Engineers Comments Regarding Surface Water Drainage

Application Reference:	AL/54/24/DOC	Reviewer Reference:	ADC/EXT2/D2134/100
Planning Officer:	David Easton	Date of Review:	08.06.2026
Site Name:	Nyton Nursery Nyton Road Westergate PO20 3UQ		
Application Description:	Approval of details reserved by condition imposed under reference AL/3/19/PL relating to conditions 18- as-built drawings of surface water drainage scheme, 19 - surface water drainage scheme, 20 - works to watercourses and 21 - maintenance and management of surface water drainage scheme.		
Assessment Number:	1 of 2

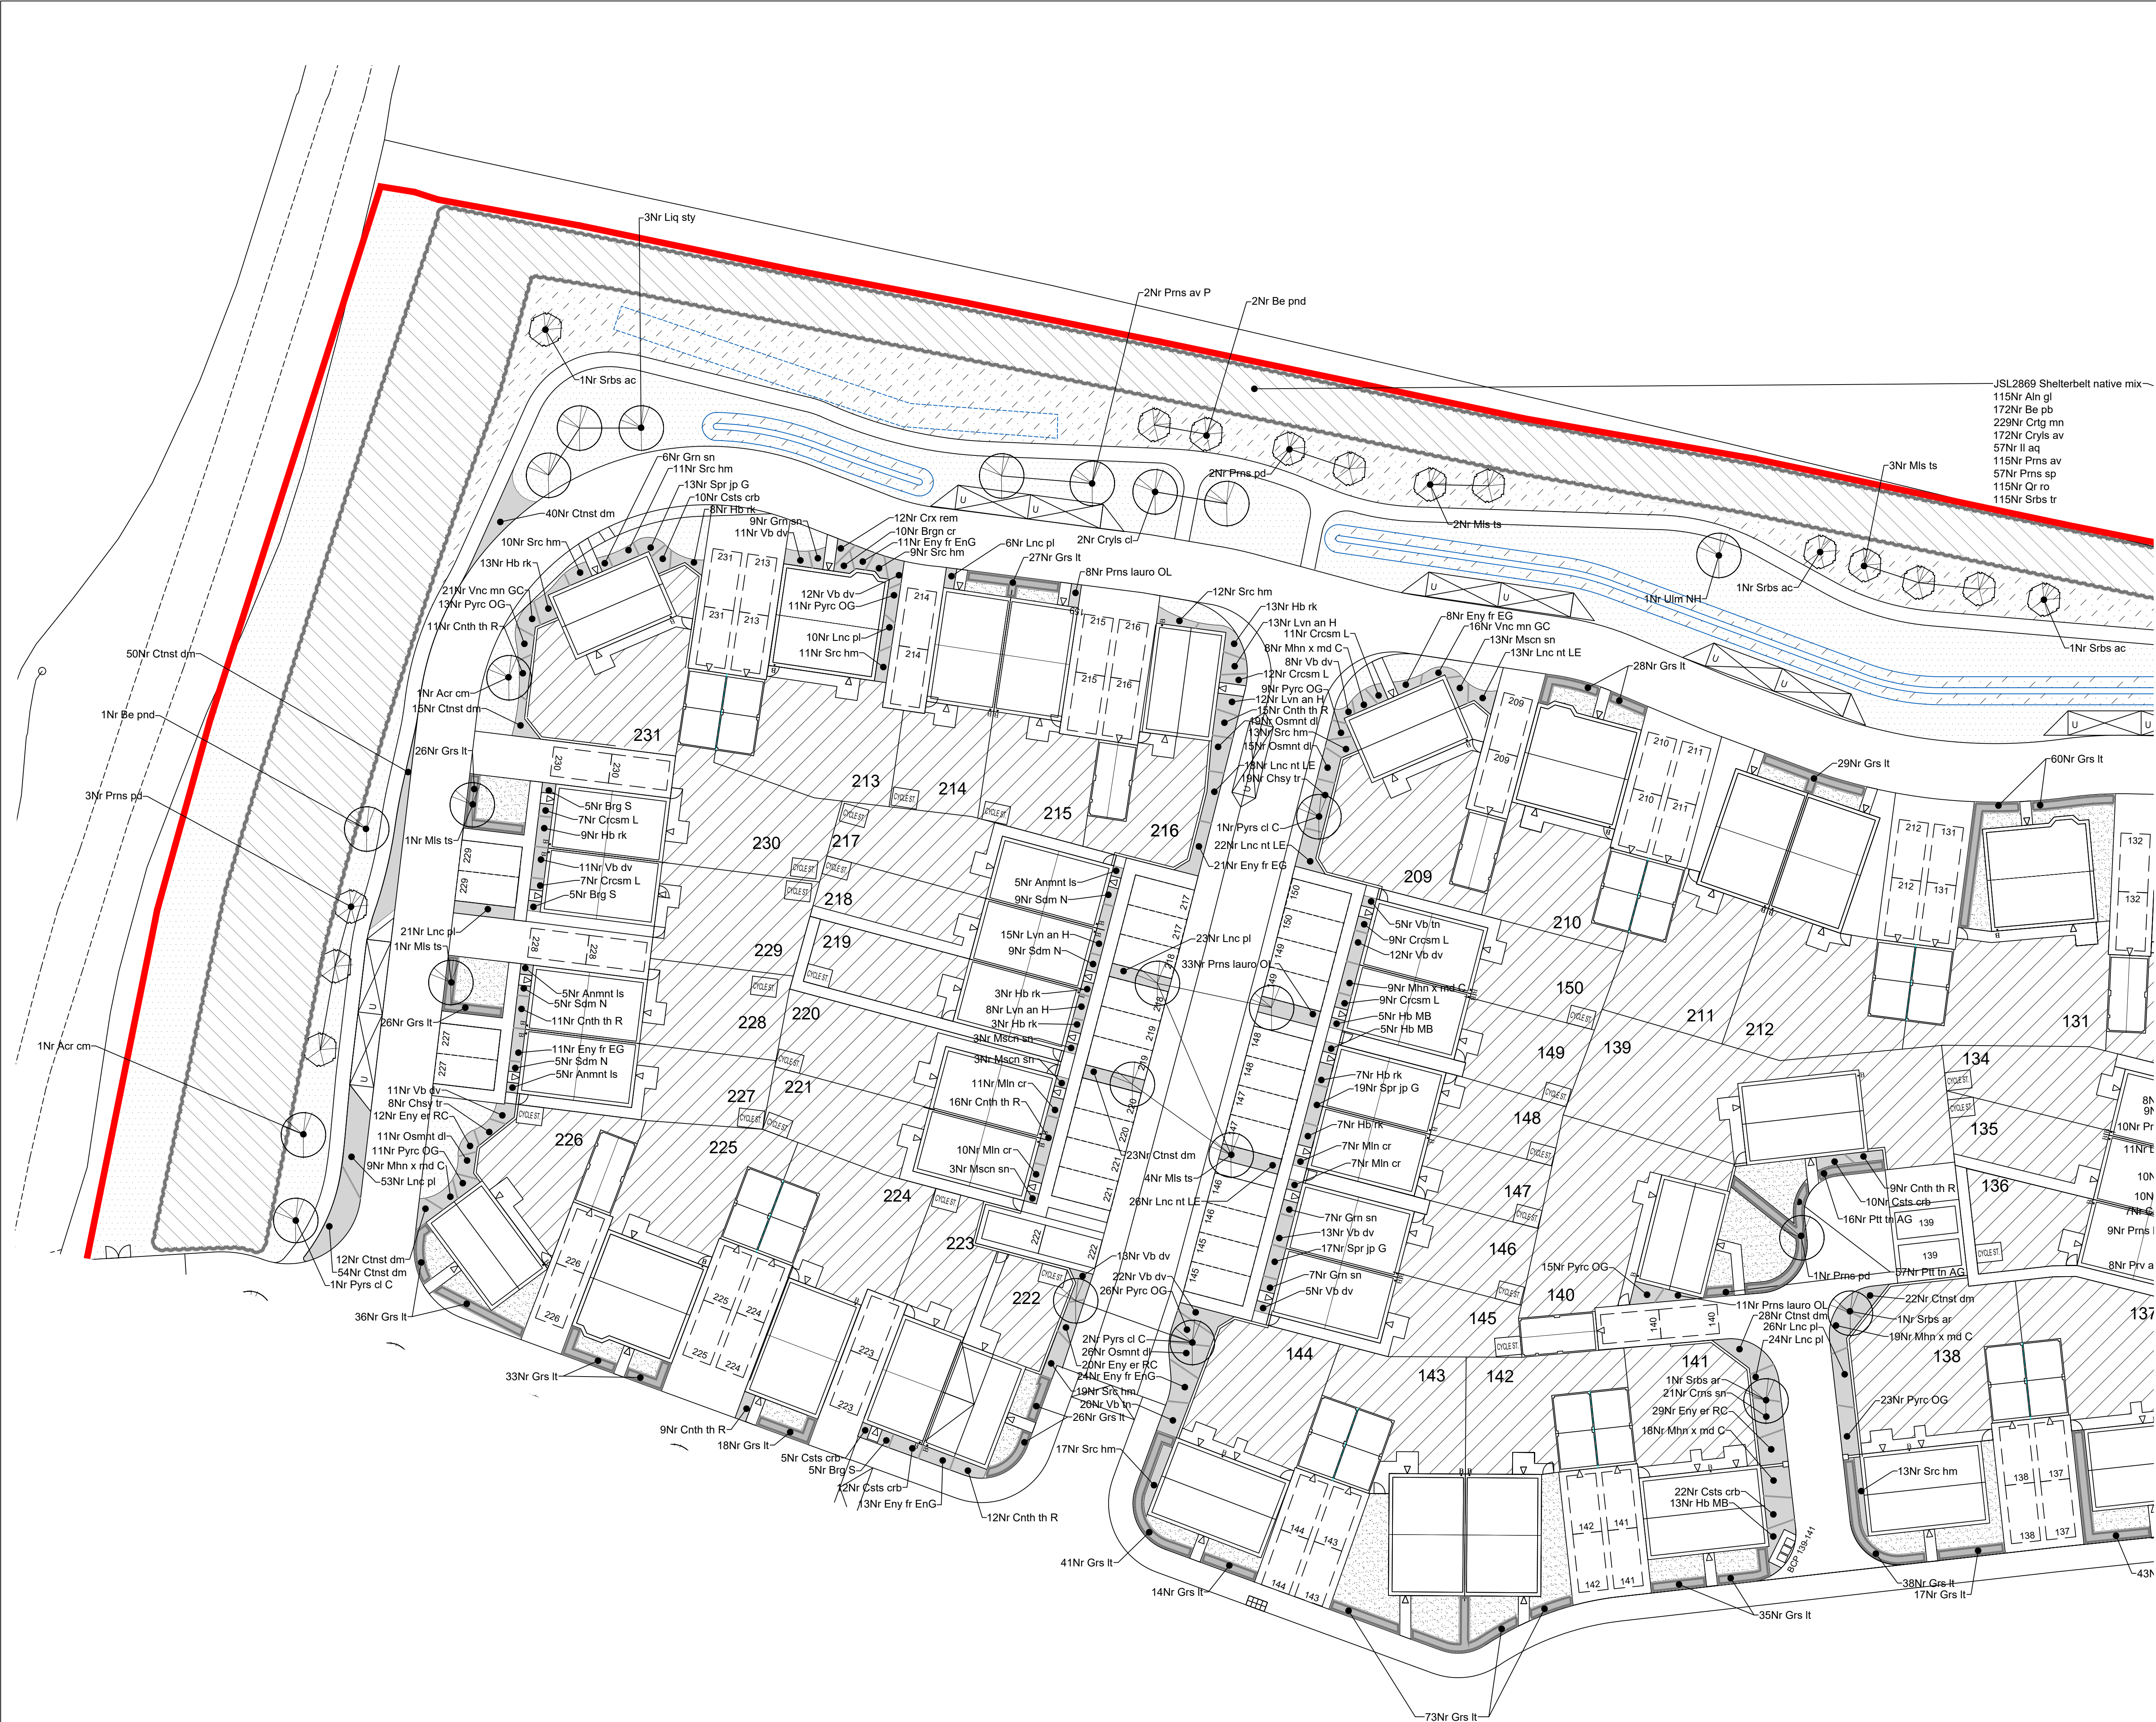
15.	ADC 28/04/2023: Please provide full details of the proposed landscaping design. Please note planting is not accepted within the	These will need to be updated by the landscapers.	2 No RPS planting drawings provided only cover part of the site. Please provide full	The designer has not provide a response or further information to resolve this comment.	Refer to RPS landscaping dwgs JSL2869_510 Rev D & JSL2869_511 Rev B

3.0m buffer/easement and SUDS features. Designer response 14/12/2023: Landscape design drawings attached. JSL_2869_510 RE PLAN and JSL_2869_511 RE PLAN ADC 21/02/2024: The landscaping plans do not show the SUDS swales and/or basins; therefore these designs do not appear to have been coordinated?		site wide coordinated drawings. Comment outstanding	Comment outstanding.	
16.	ADC 28/04/2023: Engineering drawing must show 2.0m buffer zones from all SuDS features with 3rd party boundaries. (This may vary to WSCC highway requirements). Designer response 14/12/2023: Please see drawings with 2m buffer from all swales. ADC 21/02/2024: Please refer to comment 14, these do not appear to be illustrated on the 'all' of the engineering plans.	Please see updated 3m buffer zones.	Noted. Comment closed.
